Your ref: Y/98/18/RES and Y/97/18/DOC

Land off Burndell Road, Yapton

On behalf of our client Bovis Homes ("the Applicant") please find enclosed supplementary/ updated information in response to comments received from Yapton Parish Council ("YPC") and consultees on the above applications.

DRAWING TITLE
Plots 103 & 104
House Type 8 Cypress
Floor Plans & Elevations

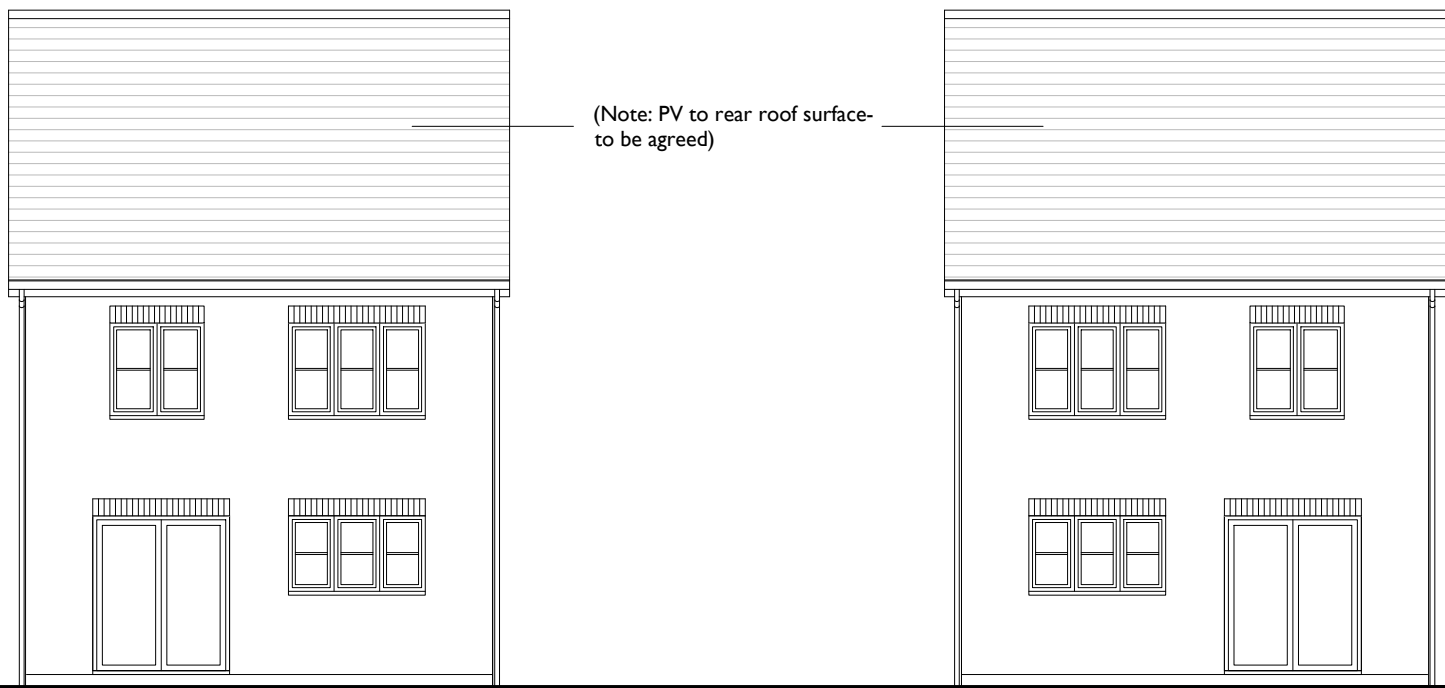
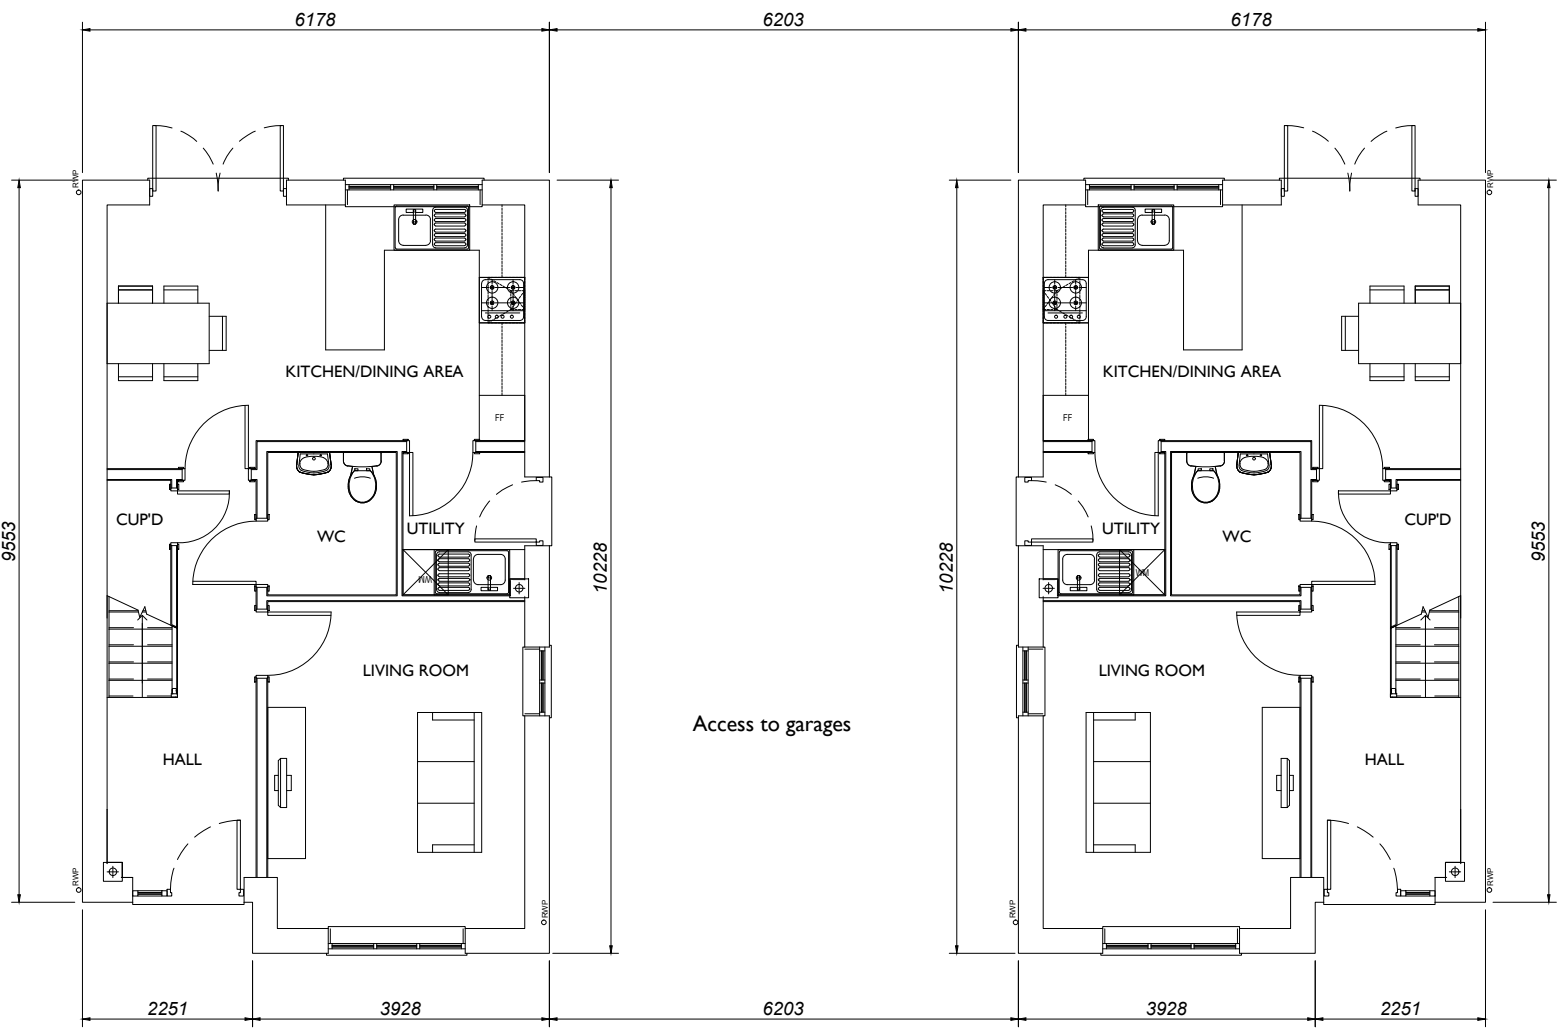
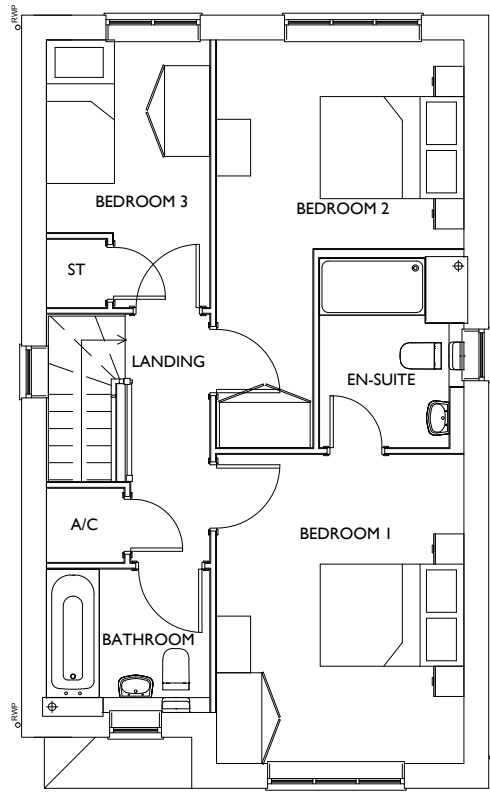
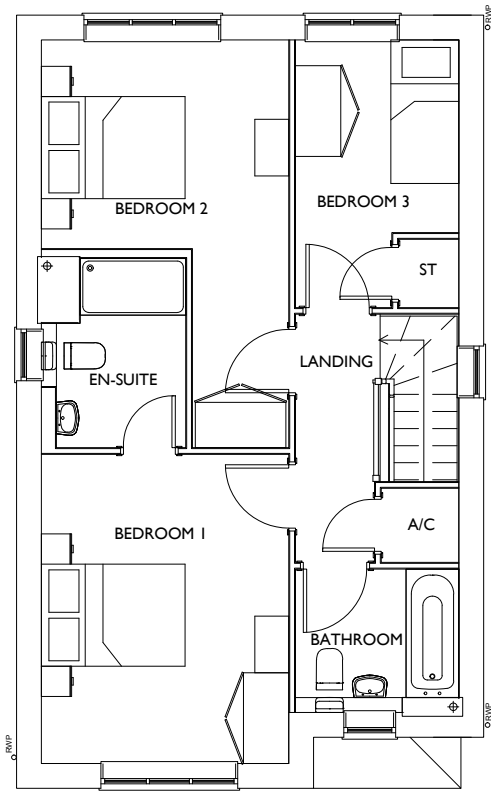
- Detached garages and additional parking spaces have been introduced to plots 1, 2, 3, 4, 5, 6, 21, 22, 23, 24, 39, 40, 48, 49, 50, 51, 54, 55, 75, 76, 79, 80, 83, 84, 88, 103, 104 and 105. Additionally, plots 79 and 89 have been shifted forward by 1m in order to create the detached garages for these plots.
- Plots 6, 7 and 105 have been pulled back by 1m to stagger the frontage building line in response to the Parish Council's comments.
- The boundaries to plots 17, 28, 29, 31, 36, 77 and 78 have been rounded off and realigned in order to meet the Applicant's technical standards.

DRAWING TITLE
Plot 108
House Type 7 Spruce
Floor Plans & Elevations

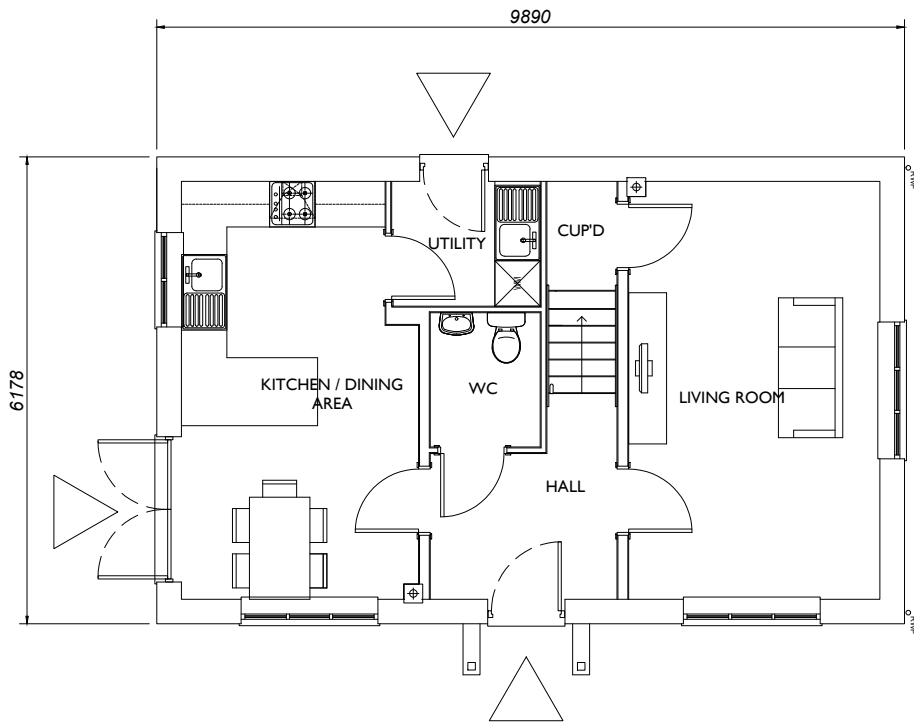
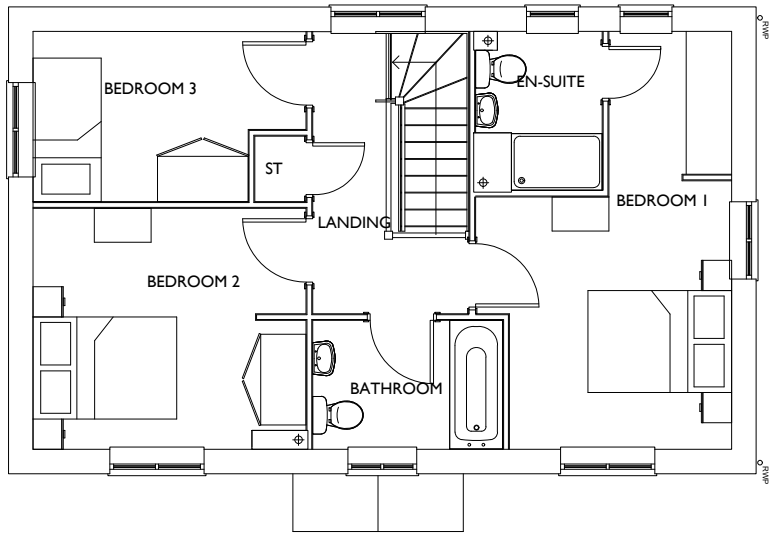
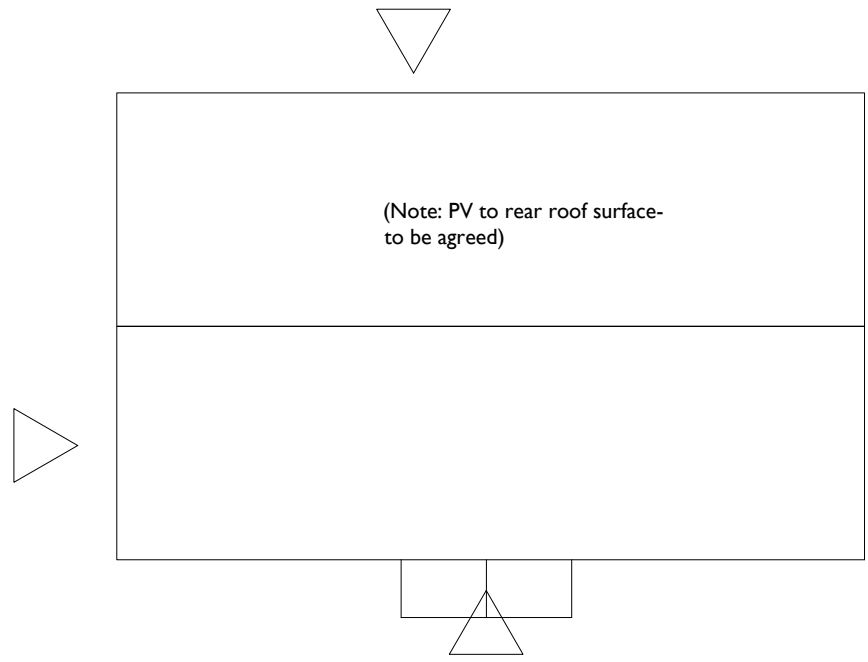
- The secondary side windows to the living room and bedroom 1 have been removed from plots 47 and 87.
- Windows have been added to the ground floor toilet and first floor bathroom for plots 55 and 75. The side window to the hallway is now non-opening and obscure glazed.
- In response to the Parish Council's comment on the need for additional variety within the pallet of proposed external materials, flint has been introduced to dwellings on plots 53, 89 and 108 as well as tile hanging to front gable of dwellings on plots 18, 28, 46 and 86.

BOVIS HOMES
scheme: Land off Burndell Road Yapton
client: Bovis Homes
drawing: Hard Landscape Proposals
date: Nov. 2018
scale: 1:200@A1
drawing no: BOV22172 12E sheet 4
drawn: AE checked: DKM

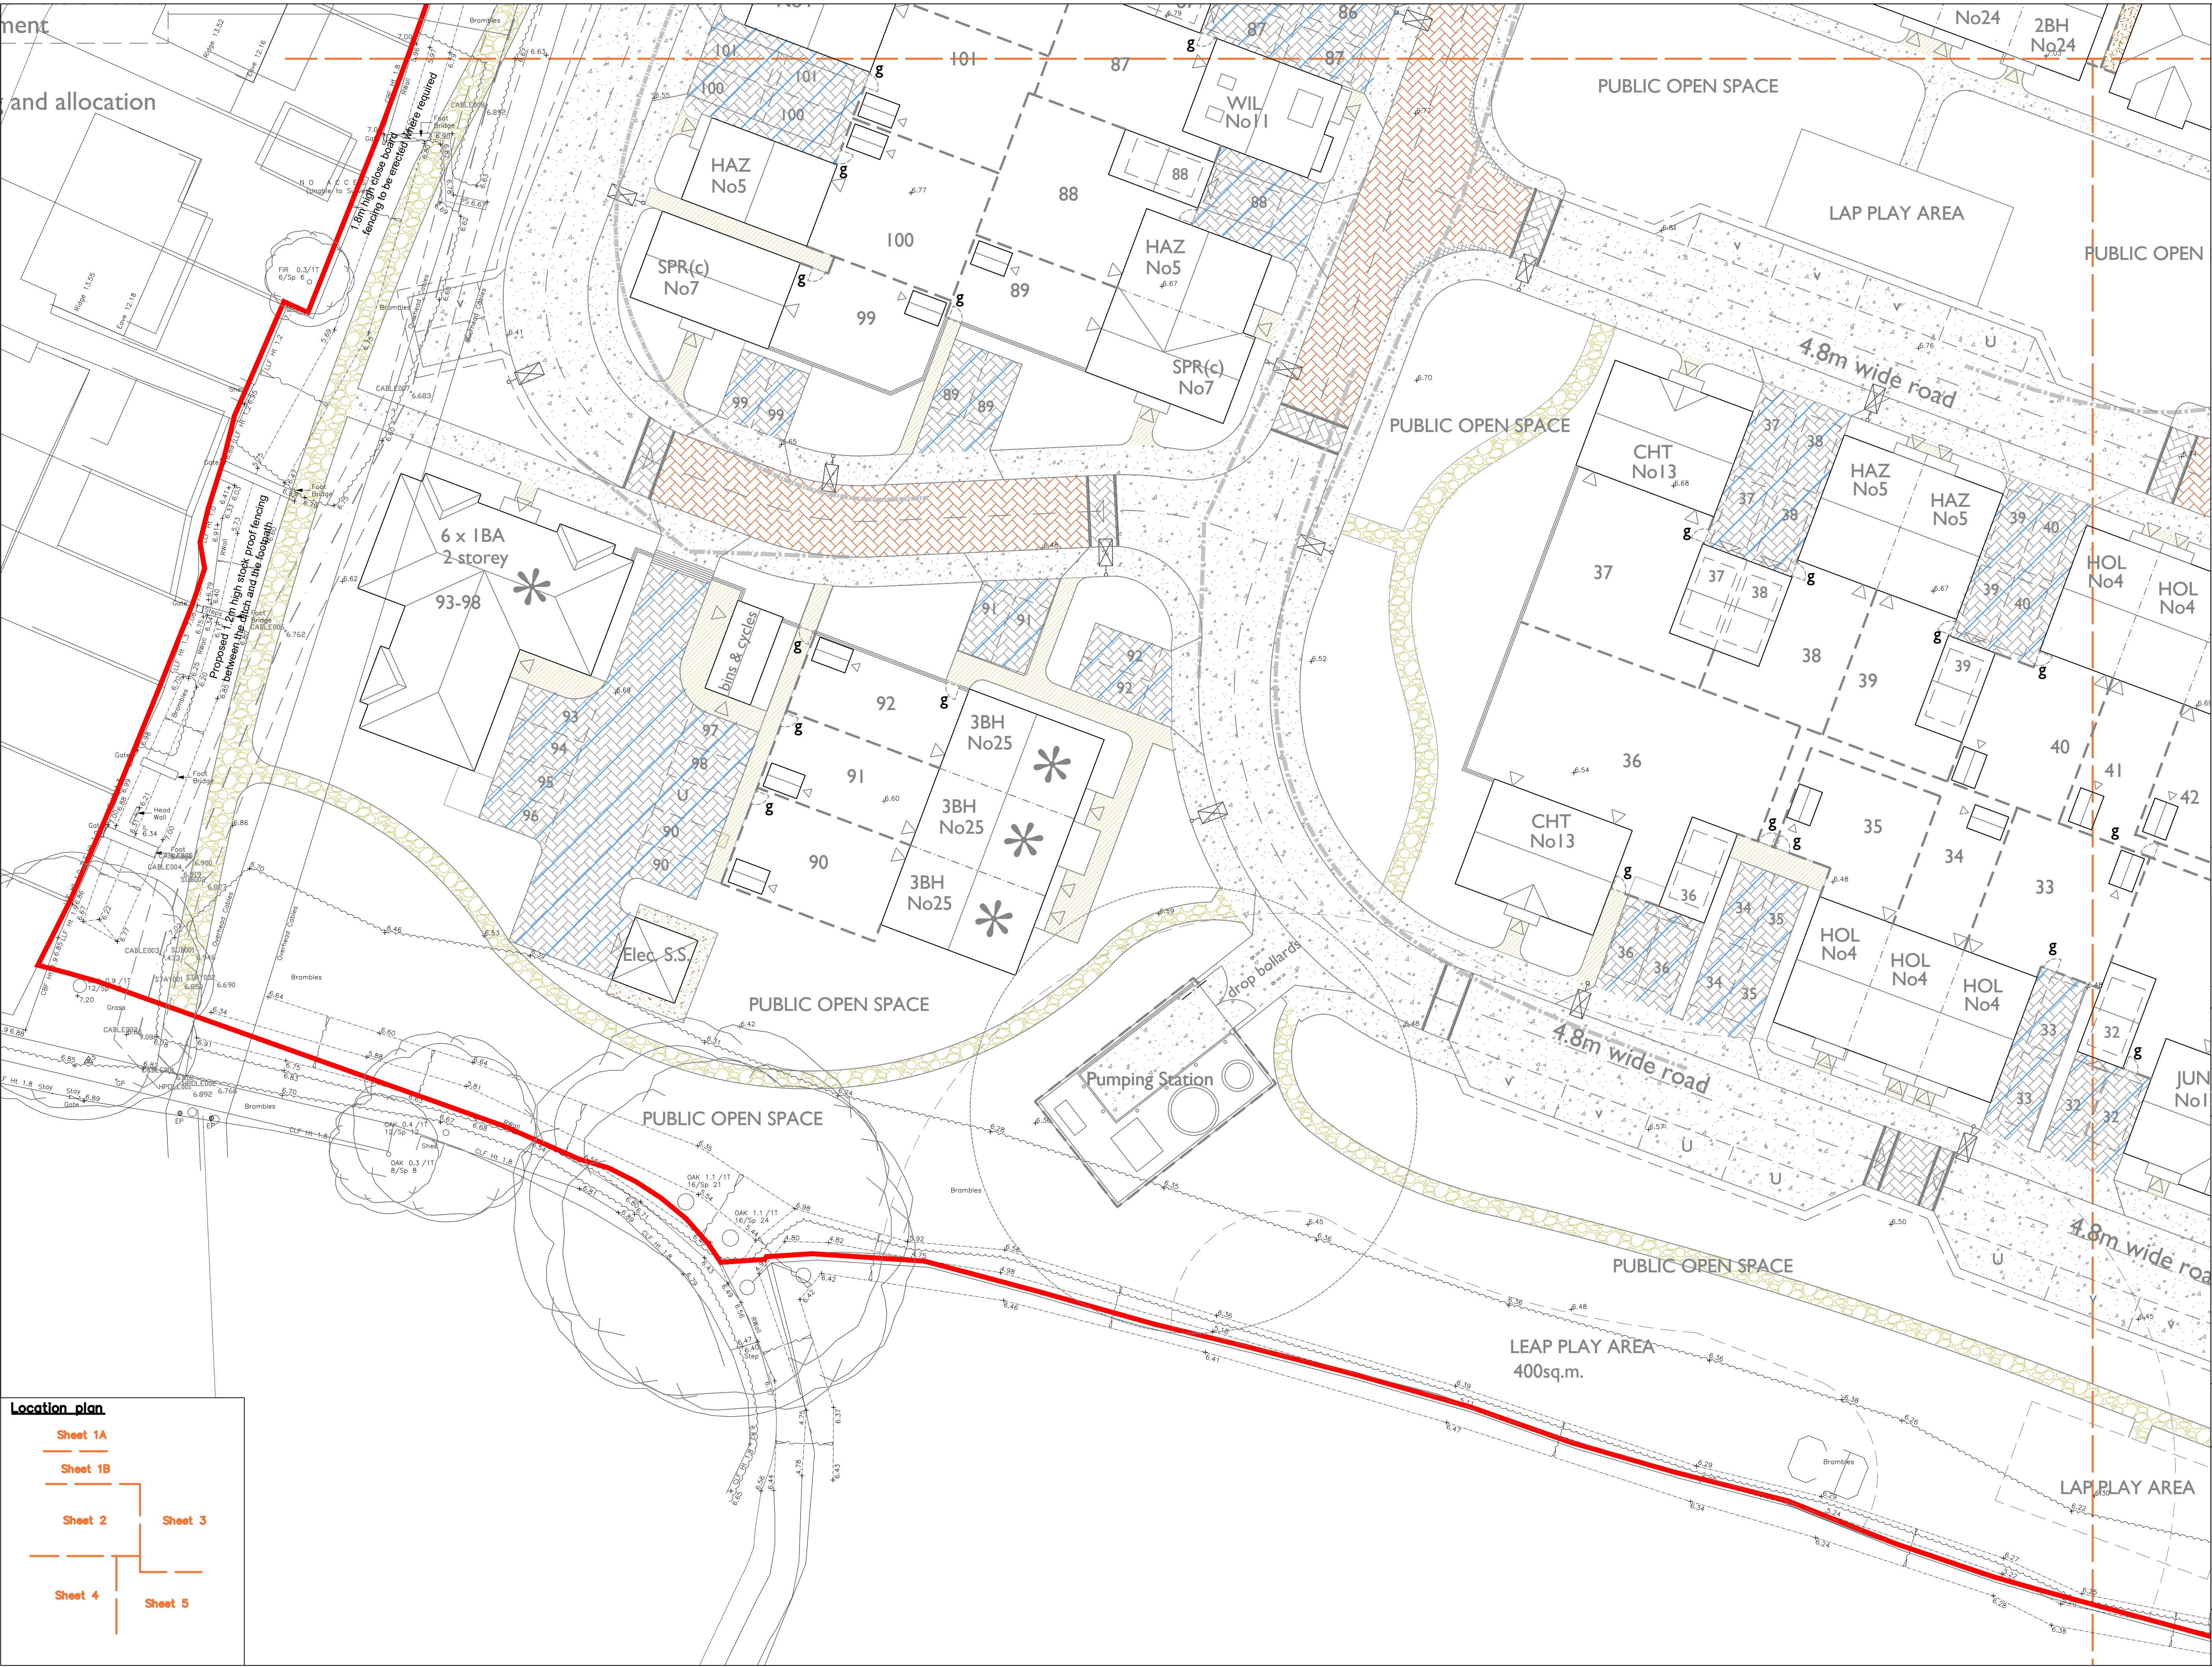
The Applicant acknowledges that YPC are concerned over the drainage ditch and we are therefore proposing a 1.2m high post and rail fencing between the ditch and footpath to safeguard the public using the footpath. The landscaping plans are being updated and will be submitted in due course to show this.
